Town & Country Planning (Control of Advertisement) (England) Regulations 2007 (as amended)

Application No: CM/3/22/A
Site Address: Maidenhead Aquatics Crookthorn Lane Climping BN17 5SN
Description of works: Installation of 1 x internally illuminated fascia sign.

Thank you for your internet representation made on 22nd February 2022 which has been recorded as an objection with the comments as follows:

DRAWING TITLE
As-Existing Elevations with Sign 1 Details

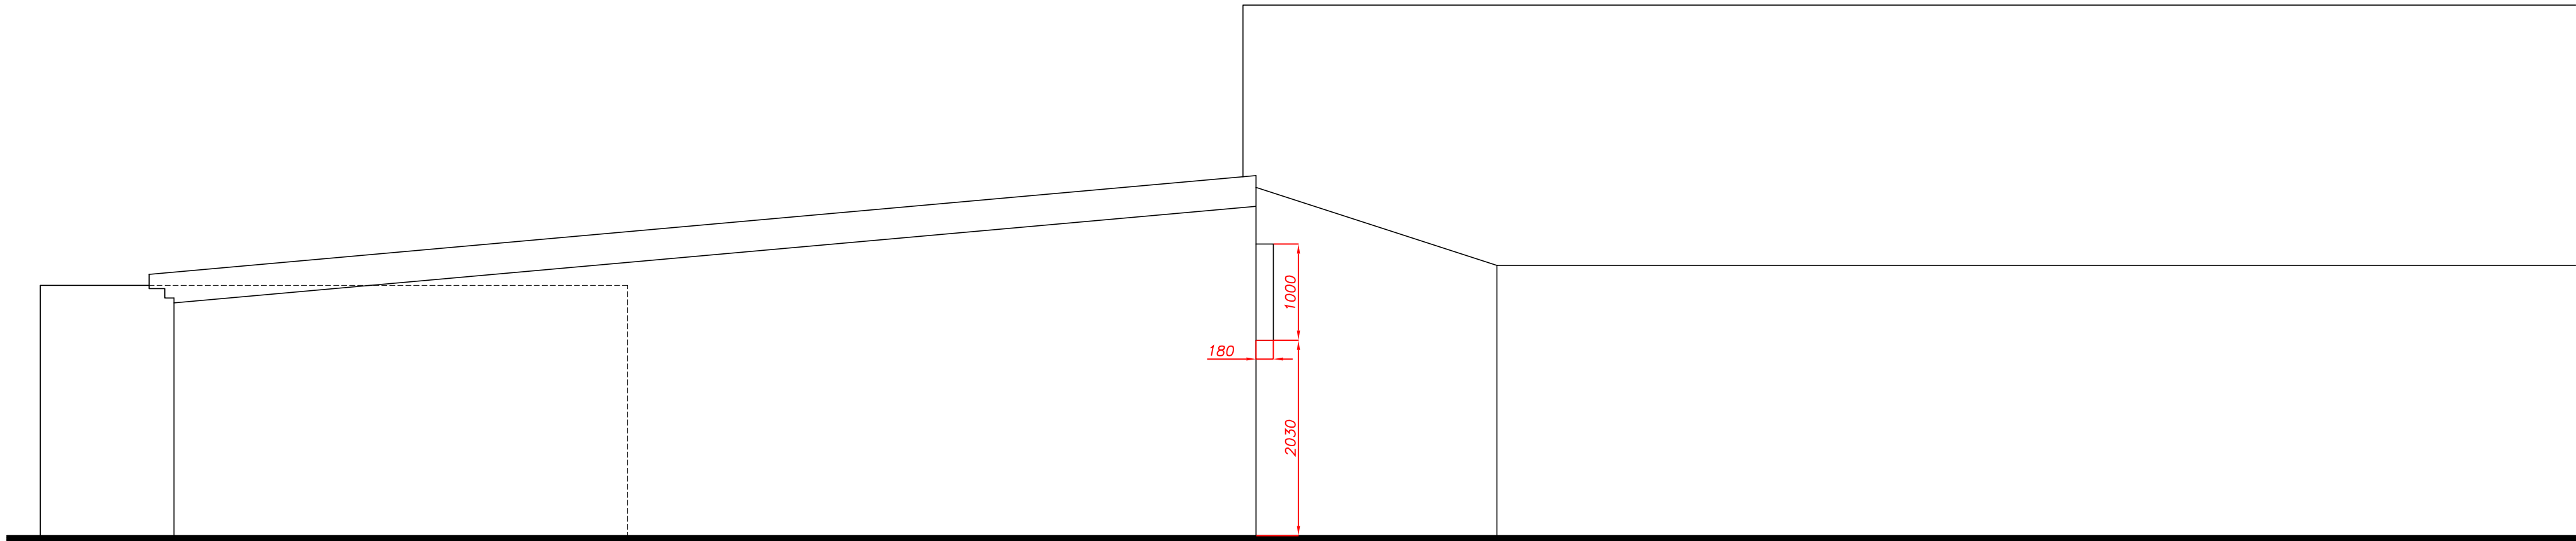
This internally illuminated, metal and acrylic fascia sign for Maidenhead Aquatics is totally out of character with the surrounding rural and dark sky area of Climping Village.

The size, choice of colours and level of illumination of the sign are a distraction risk to vehicles travelling eastwards along the A259, at an already dangerous, partially obscured site entrance/exit point and the nearby busy junctions with Climping Street and Yapton Road.

The local rural environment will gradually be turned into an urban environment by this kind of illuminated advertising signage, with a corresponding negative impact on wildlife and its natural habitat.
